OXFORDSHIRE COUNTY COUNCIL'S RESPONSE TO CONSULTATION ON THE FOLLOWING DEVELOPMENT PROPOSAL

Application no: 14/01888/F-2

Proposal: Erection of two local centre buildings - one to contain four apartments (3 x 2 bed and 1 x 1 bed) over one retail unit and a surgery and the other to contain four apartments (2 x 1 bed, 1 x 2 bed and 1 x 3 bed) over three retail units and a nursery.

Transport

Org. no 1419 | 101 | Rev G

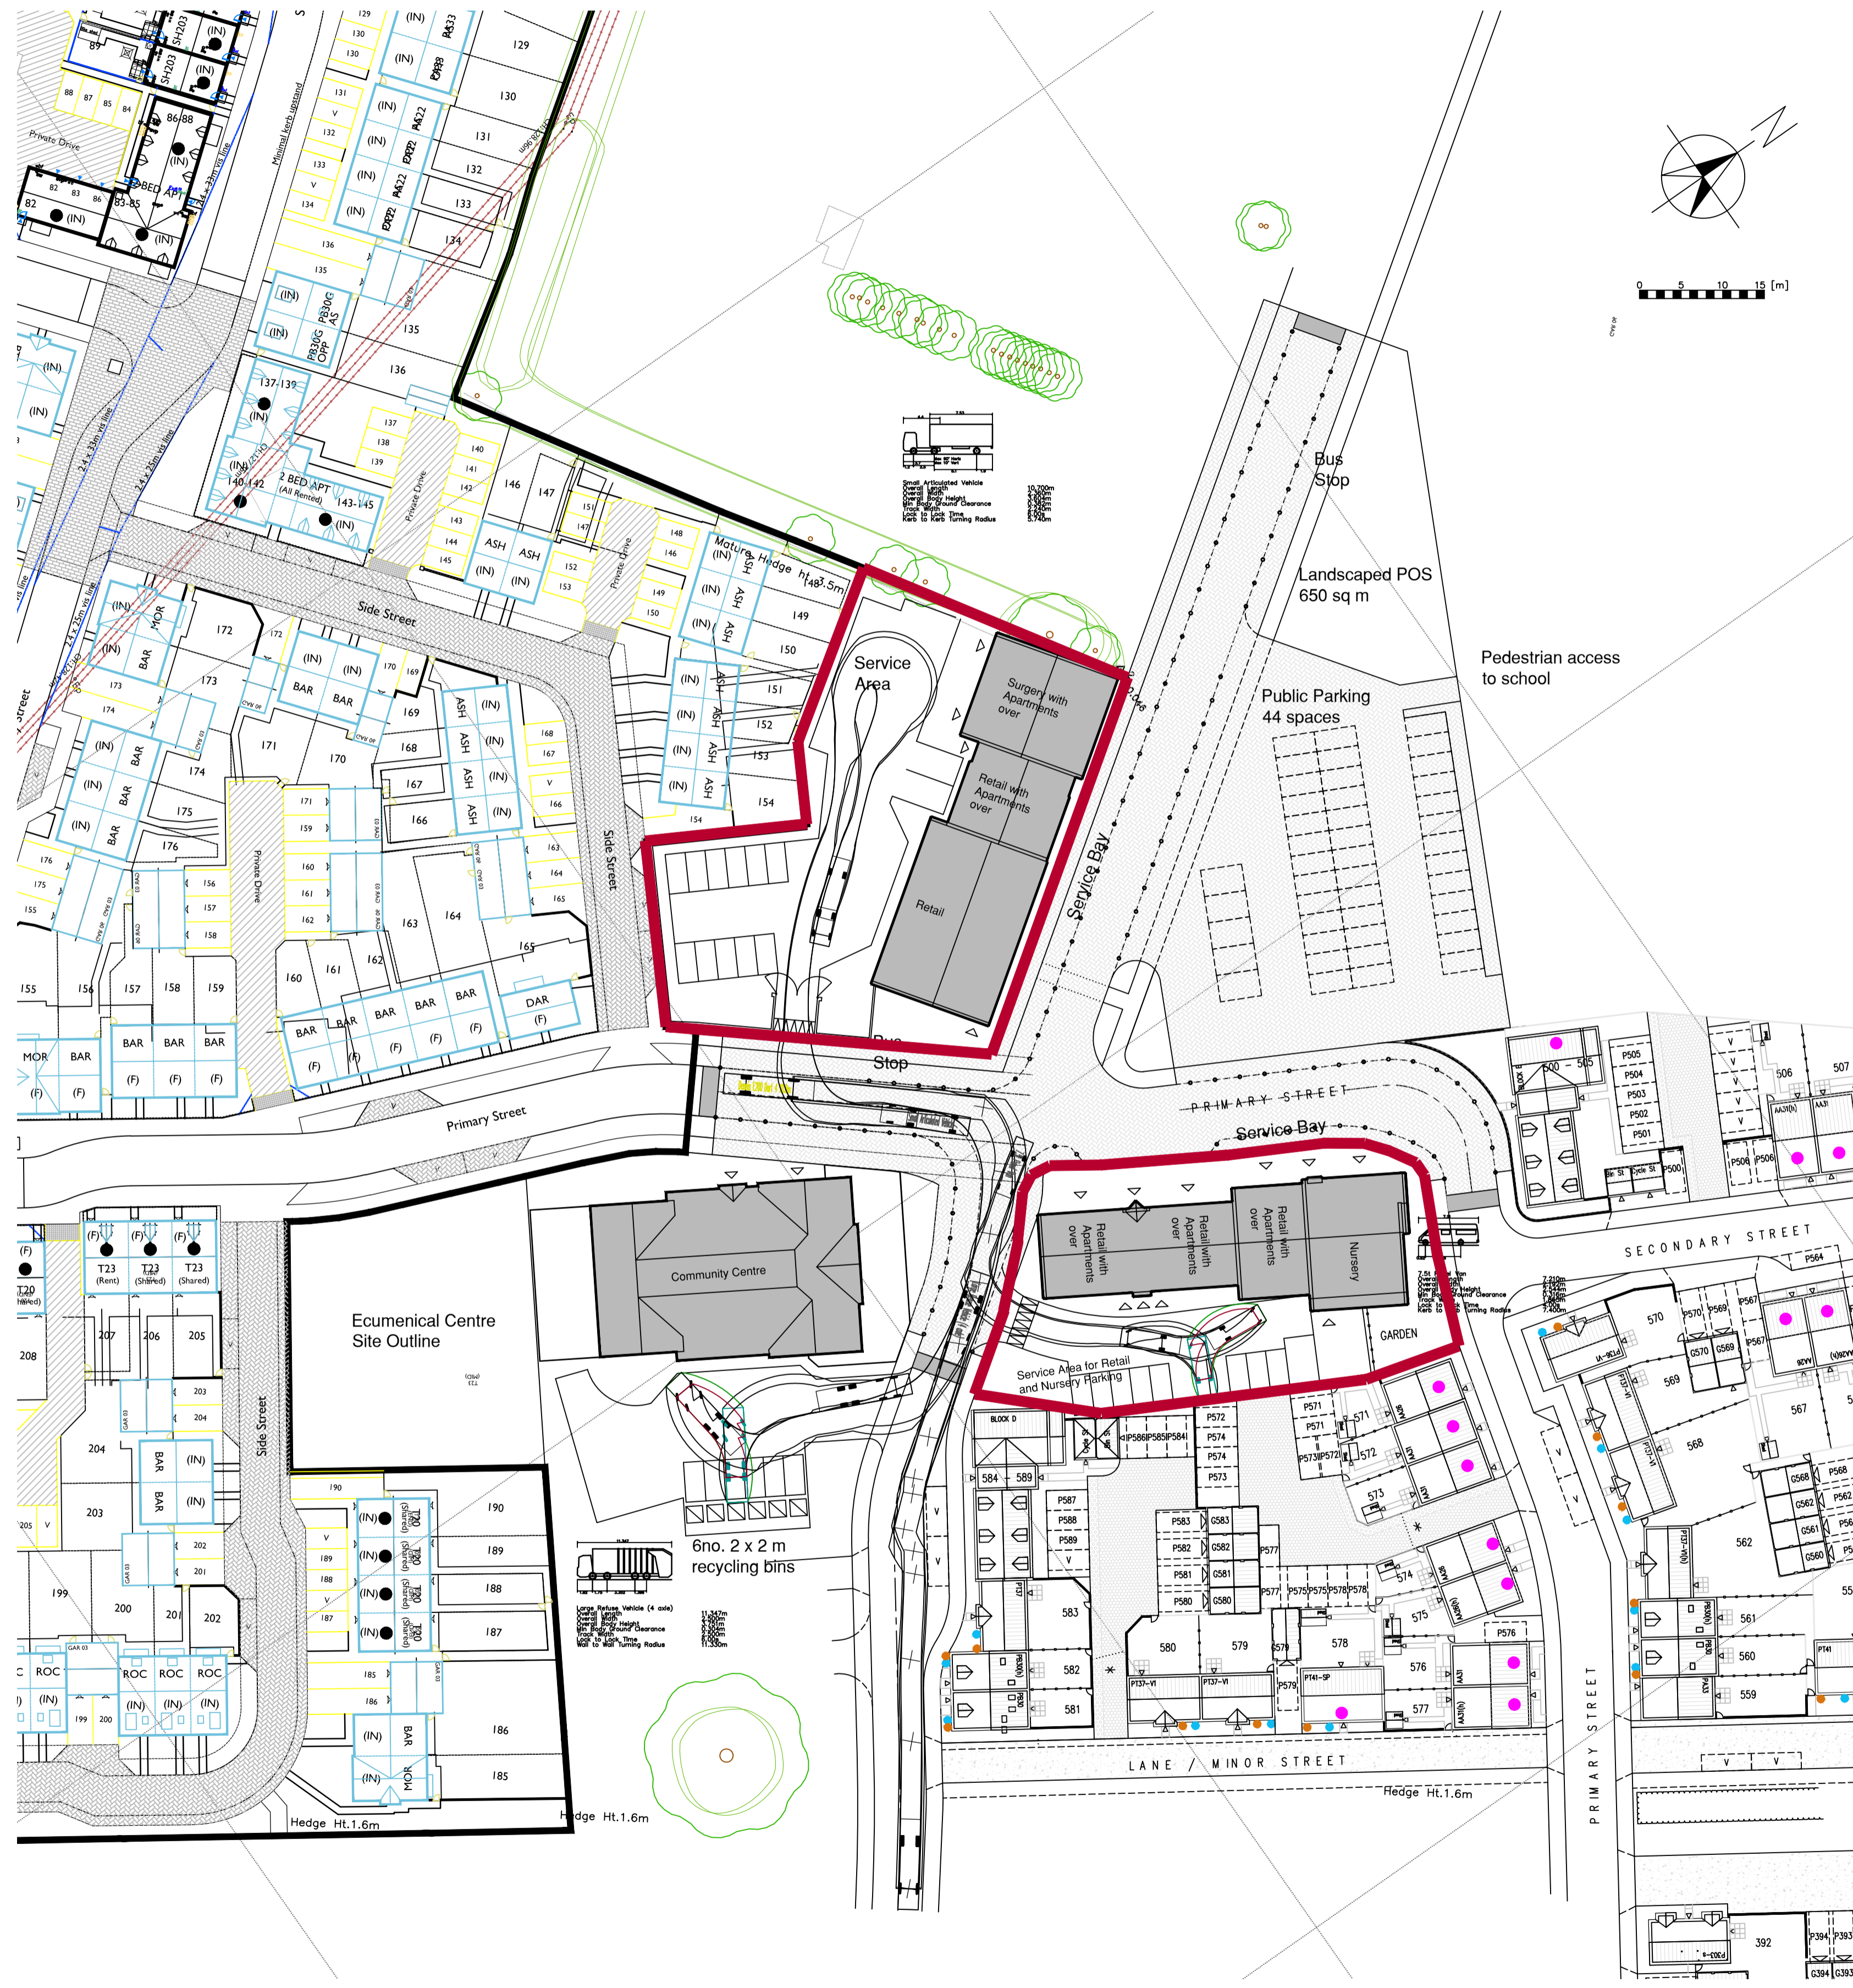
Carriageway layout is different from that of the approved spine road planning layout. In particular the bus layby and service layby adjacent to the surgery/convenience store are not shown. It is important to show the building accesses and yard accesses in relation to that layout. It is recommended that the layout drawing is amended to show the correct kerblines of the spine road.

The tracking of vehicles in and out of the two yards was reviewed as part of the spine road application. Because it could not be shown that large vehicles (which typically deliver to

convenience stores) could enter and exit the yard for the convenience store and surgery premises due to the constraints of the spine road, it was agreed that a service bay capable of accommodating large articulated lorries could be located on the spine road outside the front of the building. This has not been shown on the layout plan. The plan should be revised to show the route that the deliveries will take into the store once offloaded – will cages be pushed through the store? As there is no access path from the front to the back of the store, the only alternative seems to be on the footway around the corner and into the service yard, but this could interfere with pedestrians and people waiting at the bus stop, so would not be acceptable.

With regard to the retail and nursery building, the developer has asserted that no vehicle larger than a 7 tonne panel van would be used, and tracking has been provided to show that this can enter and exit from the spine road and turn around within the service yard. I have concerns that this yard may also be used as parking for nursery drop off – see query under parking below.

It is assumed that parking within the rear yards is for the residential units and staff. However, spaces have not been allocated. The layout plan should be revised to show the allocations. I note two disabled bays have been provided behind the surgery – I assume these will not be for customers as the yard is gated.

Gates are not shown on the yard to the rear of the nursery. I would be very concerned if this was publicly accessible as it could be used for nursery drop off, and this would not be suitable for a service yard. Access arrangements for the nursery need to be confirmed, and provision will need to be made for buggy parking, and parent/child car parking.

No cycle parking is shown for this development – this must be provided and due to the constraints of the site I would recommend that this is not conditioned because it is likely to be challenging to accommodate.

There is no indication of bin storage – this was highlighted in our previous response.
